From: Hebe Smith
Sent: 29 May 2025 14:40
To: Planning.Responses
Subject: FW: Application AB/41/25/HH - 24 Stewards Rise, Arundel
Attachments: REV A Proposed Elevations and Plans.pdf; REV A Existing and Proposed Section AA&BB.pdf; Action Sheet v4 Electronic Version AB-41.docx

Subject: Application AB/41/25/HH - 24 Stewards Rise, Arundel

**Existing and Proposed Section AA & BB**

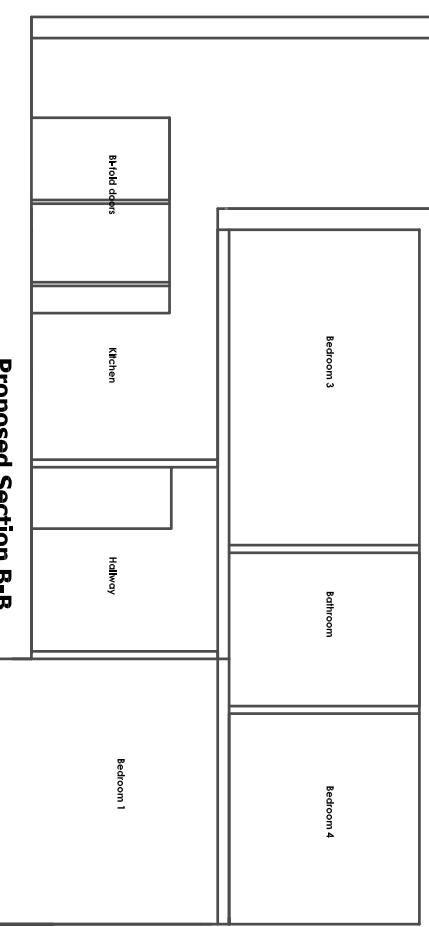
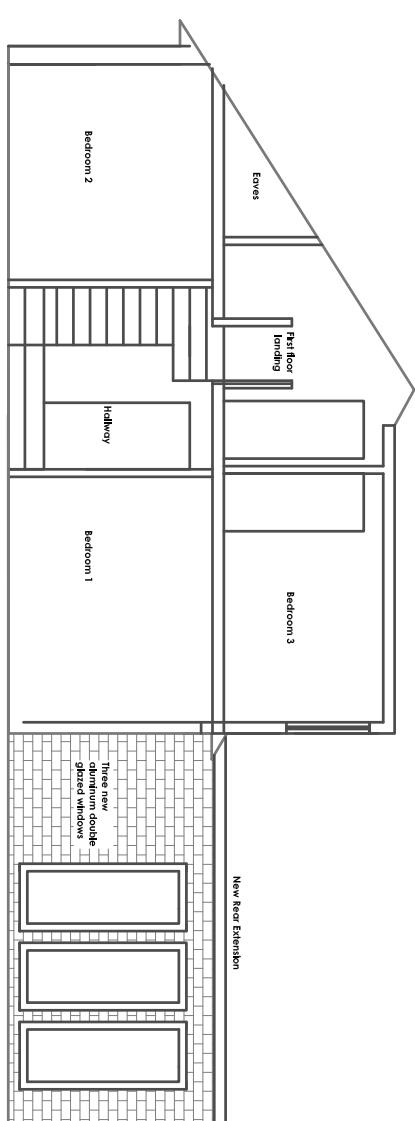
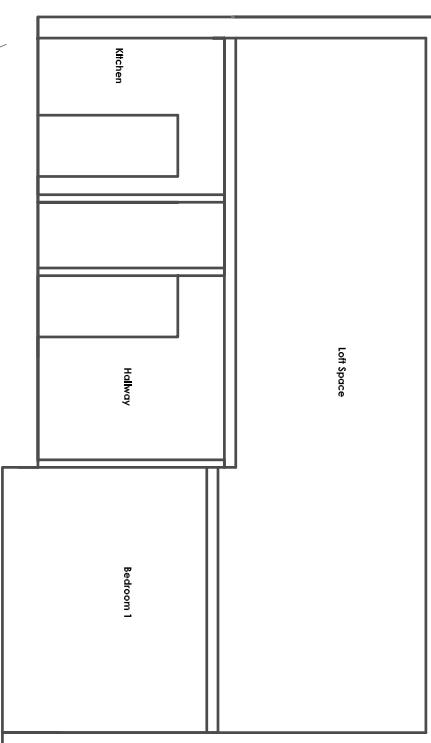
I've just been reviewing the plans for your application at Stewards Rise, Arundel. I currently have some concerns about the proposed design. Firstly, would it be possible to reduce the size of the proposed rooflights, particularly on the front elevation? Could the proposed dormer also be set in from the edge of the roof slope and possibly also set up slightly from the eaves?

Further to your email and discussions with my colleague Max Thoms this week, Max has asked me to forward his amended drawings which reflect smaller Velux windows and the rear dormer set back approximately 300mm, as requested.
